Appeal Decision

Appeal Ref: APP/R5510/W/23/3318219

104 Windsor Avenue, Uxbridge, Hillingdon UB10 9BA

ROOF

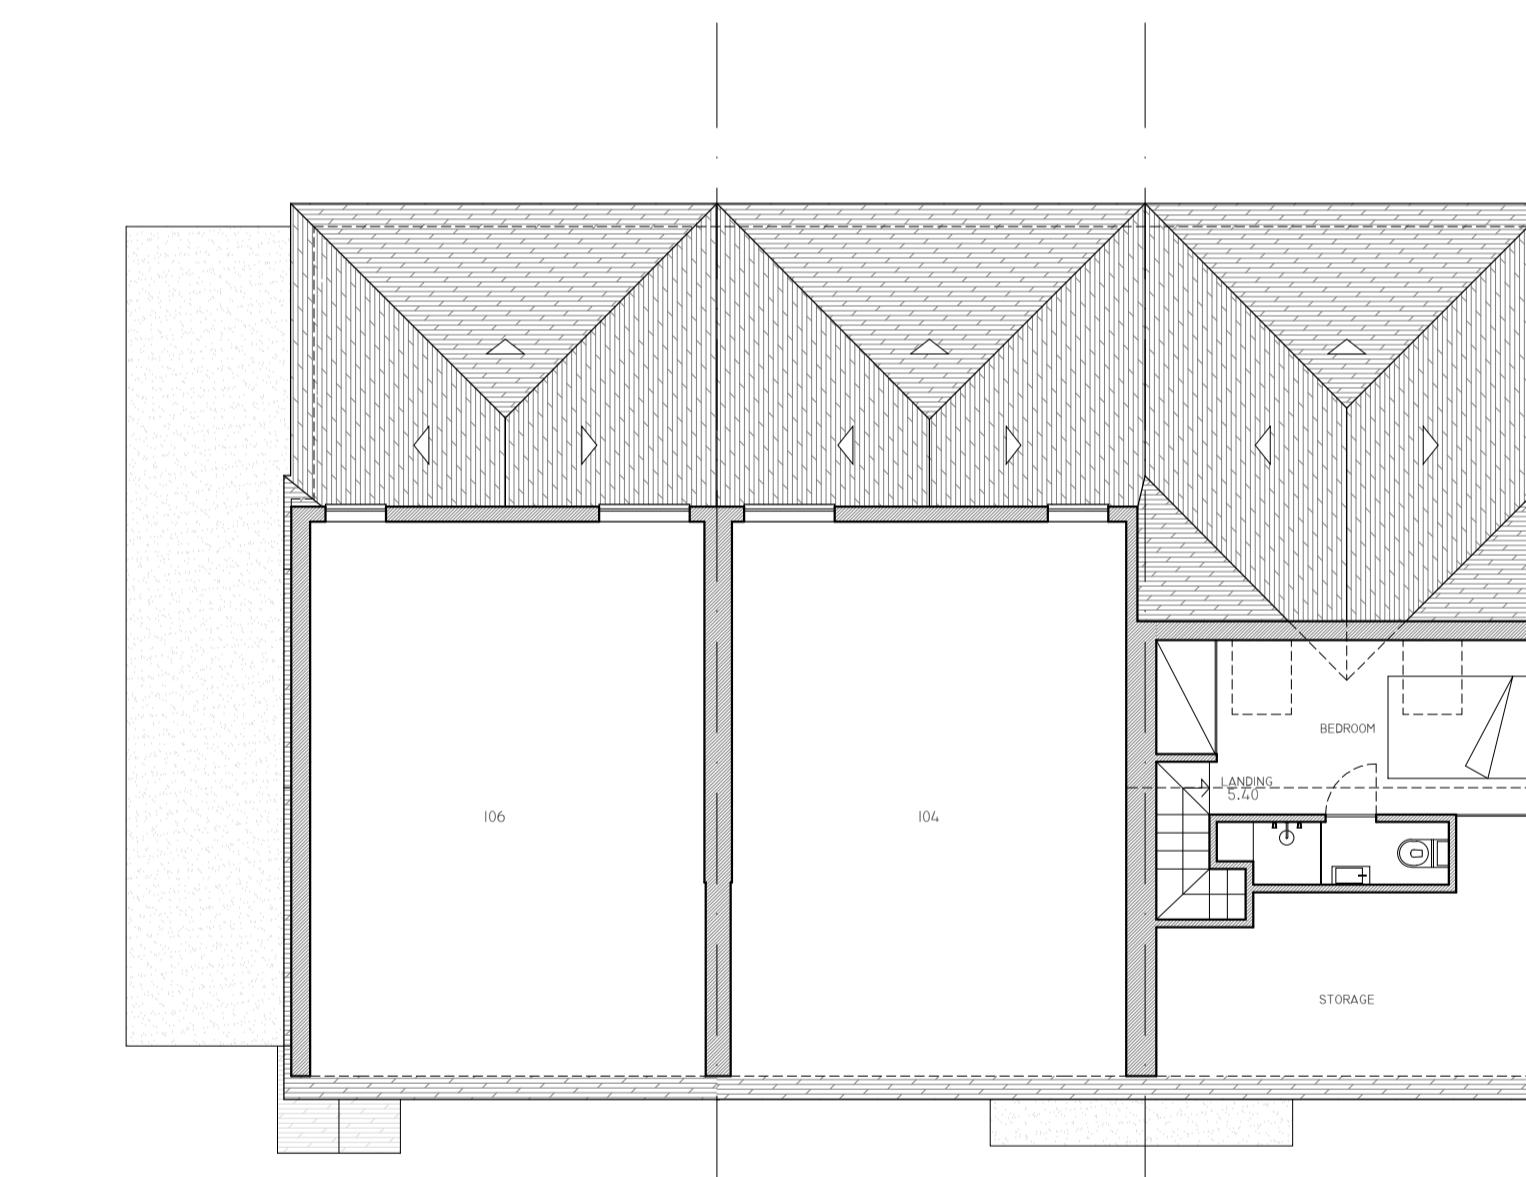
8. The proposal includes a bedroom on the second floor which would be solely lit with rooflights. The rooflights appear to be of sufficient size to provide light to the room and due to their height and position within the roof they would provide sufficient outlook for the occupiers of the proposed dwelling, particularly the second-floor bedroom.
9. I conclude that the proposal would provide satisfactory living conditions of the future occupiers of the dwelling with particular regard to outlook. It would not conflict with Policy D6 of the LP and Policies DMHB 11 and DMHB 16 of the HLP which together, amongst other matters, seek to ensure that development is of high-quality design and meets the occupiers' needs.

RIGHT SIDE ELEVATION

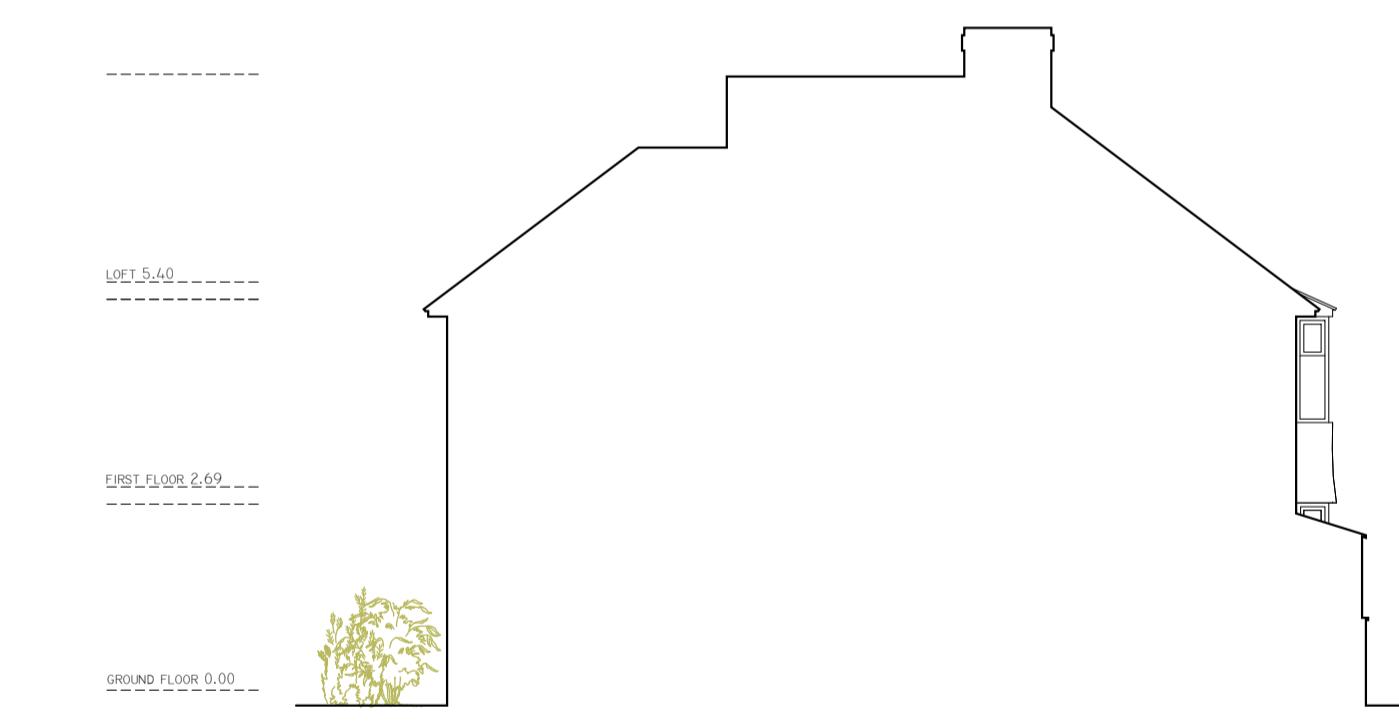
4. Regent Road has a regular building line, particularly apparent when looking towards Windsor Avenue. The space at the corner is a feature of the area and contributes positively to the character of the area. Although the proposed dwelling would be separated from those on Regent Avenue by the rear garden and single storey building, when viewed from Regent Avenue, it would be positioned closer to the rear of the footway and would appear as a bulky, cramped and prominent addition to the street.

5. It would have a different roof form than the neighbouring dwellings which have been extended with a flat roof dormer to the rear. The proposed pitched roof whilst being lower than the neighbouring dormers, would not reflect this established pattern of development and would be a bulky and incongruous addition to the street scene when viewed from Regent Road.
